Consultation Response from KC, Lead Local Flood Authority
2024/93605 Land at, Main Avenue, Cowlersley, Huddersfield, HD4 5US
Erection of 57 dwellings with access from new through road connecting Main Avenue and Windsor Road, and associated works, including engineering and landscaping
Date Responded: 16th January 2025 Responding Officer: Paul Farndale Responding Ref: 4

PROJECT / CLIENT Kirklees Cluster Sites Main Avenue, Cowlersley		PROJECT NO. N81-3084	
DRAWING TITLE Proposed Site Layout		DRAWING STATUS Planning	
PROJECT LEADER GP		DRAWING NO. 102	
SCALE 1 to 500 @ A1		DRAWING REVISION P5	
DATE 22.10.2024		REV. DATE. INITIAL. DESCRIPTION

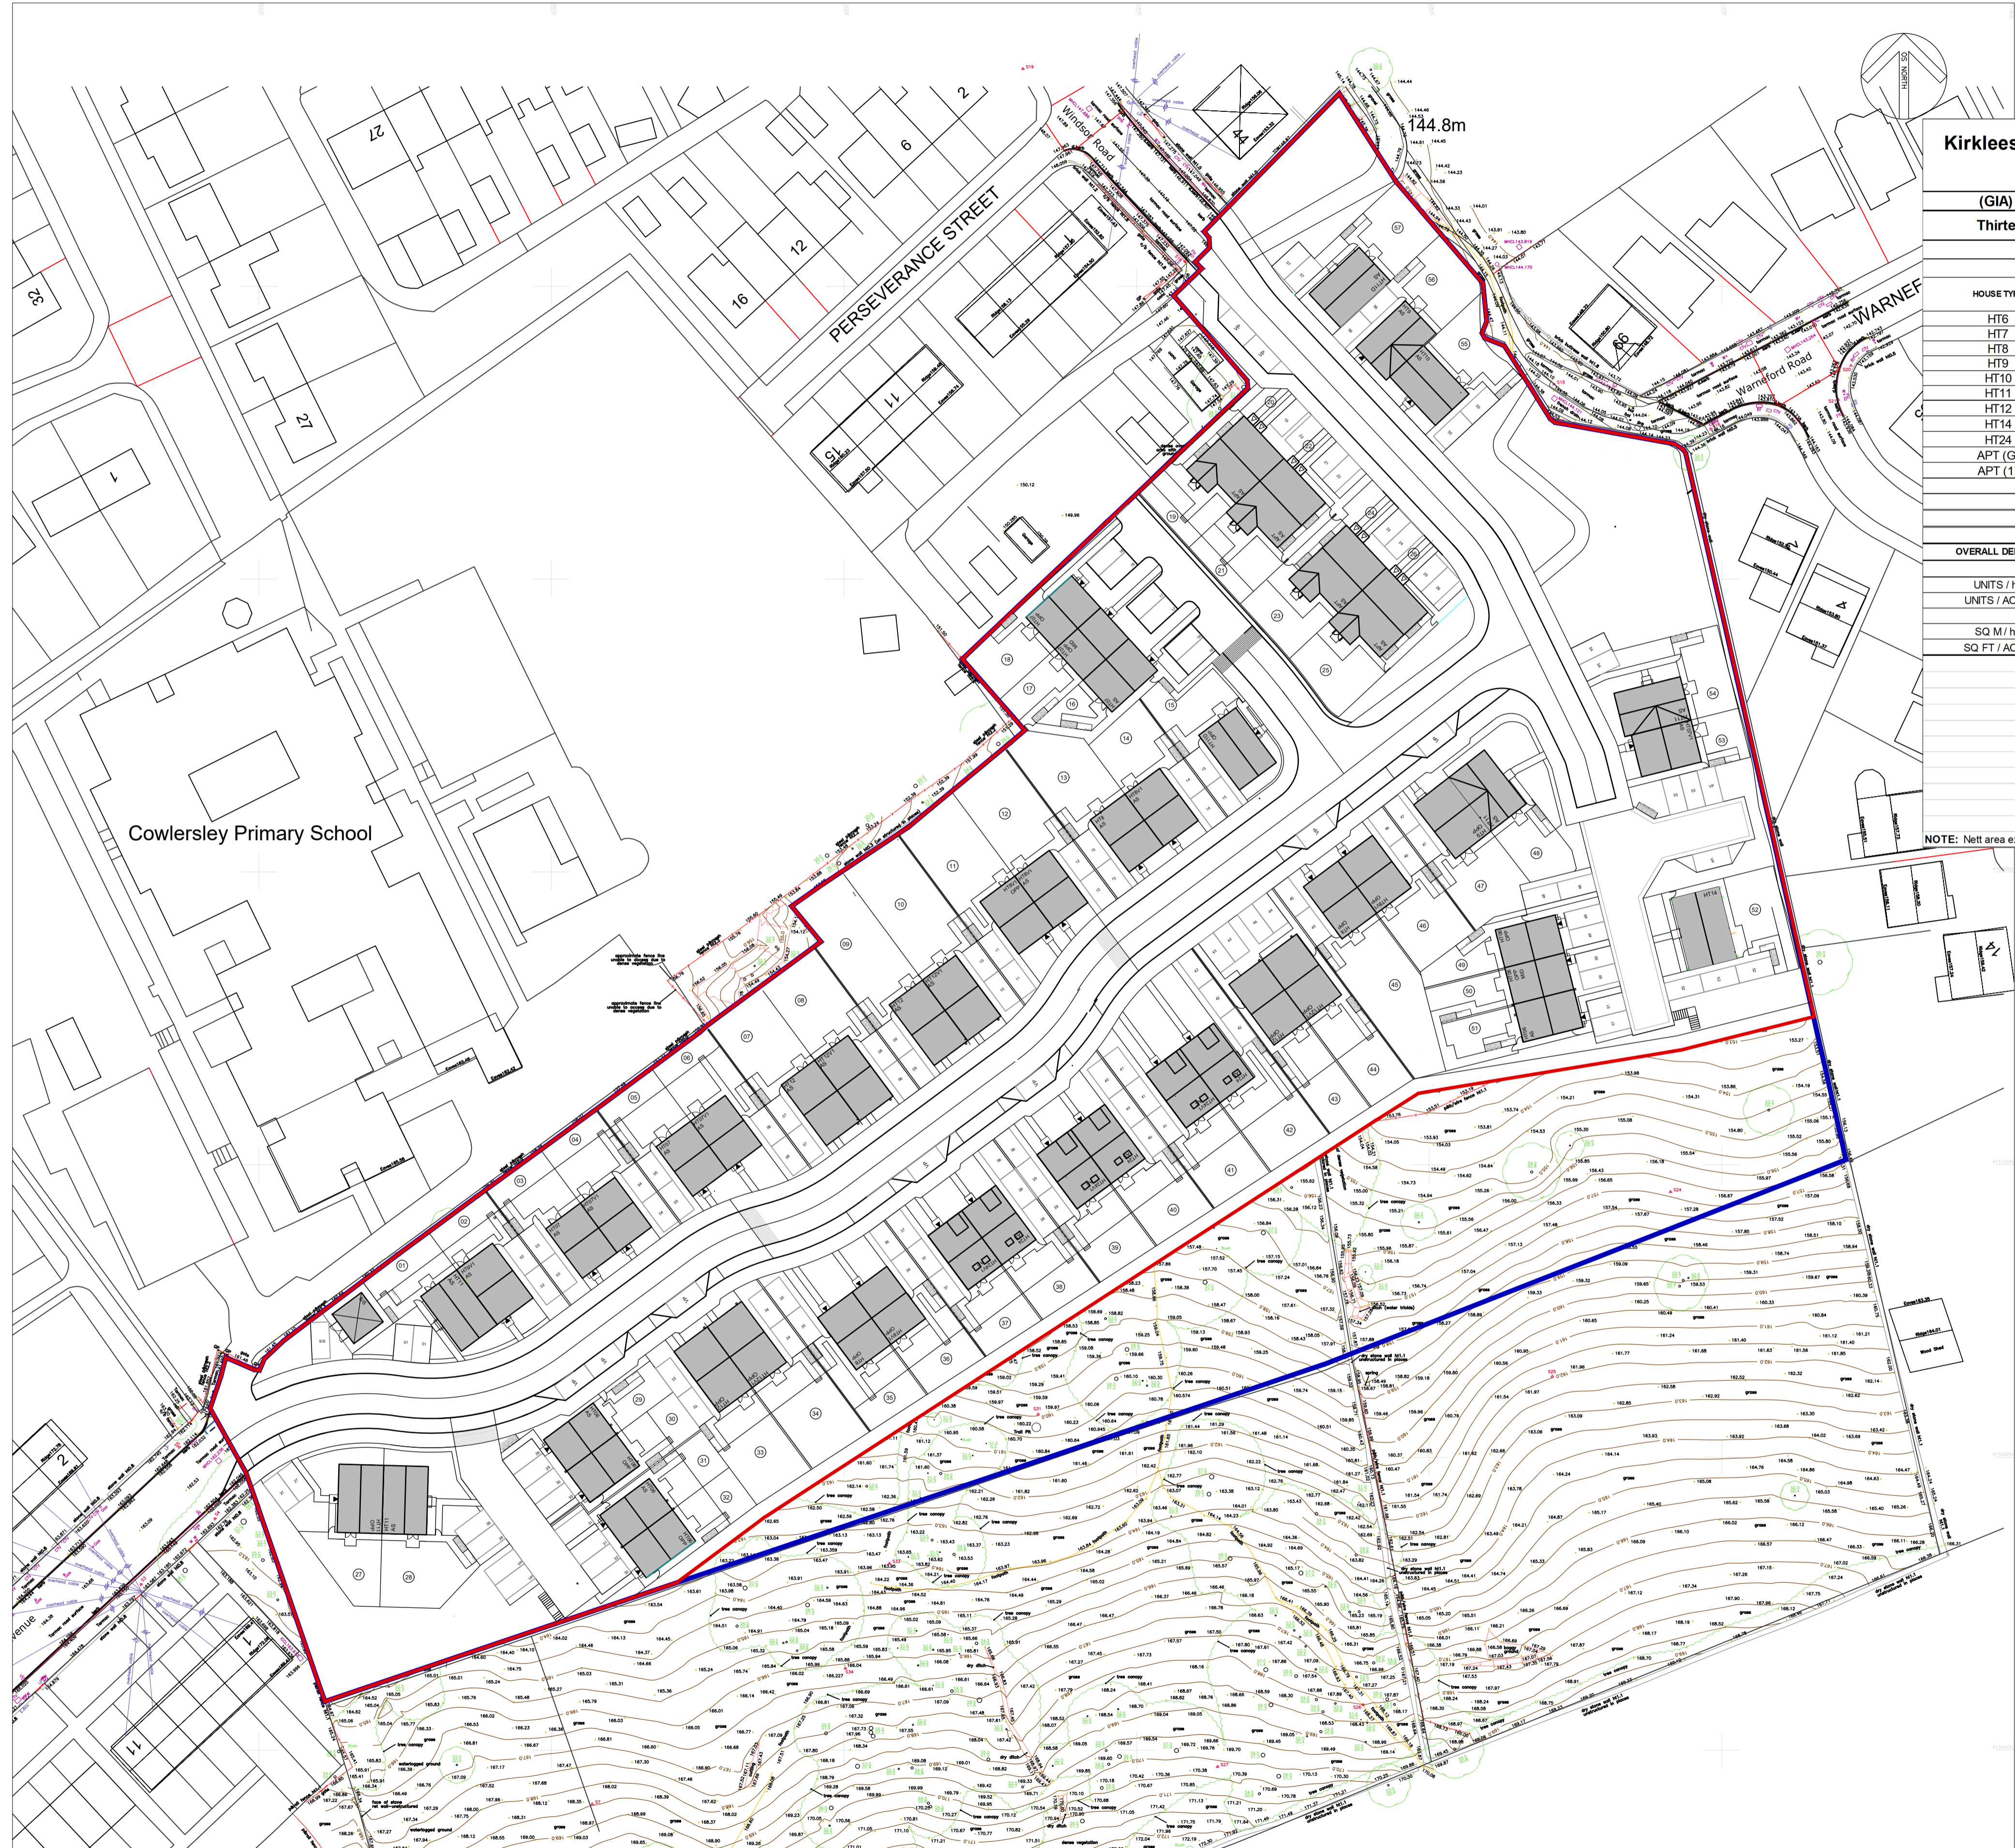
Once the parapet wall has been built, we have still not received acceptable levels that clearly demonstrate that water will be moved to the eastern side of the site and cascade down installed stepped access. At the moment, levels suggest water will pond in a depression away from these steps.

Due to the flooding around adjacent houses, it is good practice that the site can accommodate a 2 year/6-hour storm event on site prior to attenuation being installed. The risk of flooding at the eastern border of the site has not been considered. A formal plan with evidence of volume control will be required.
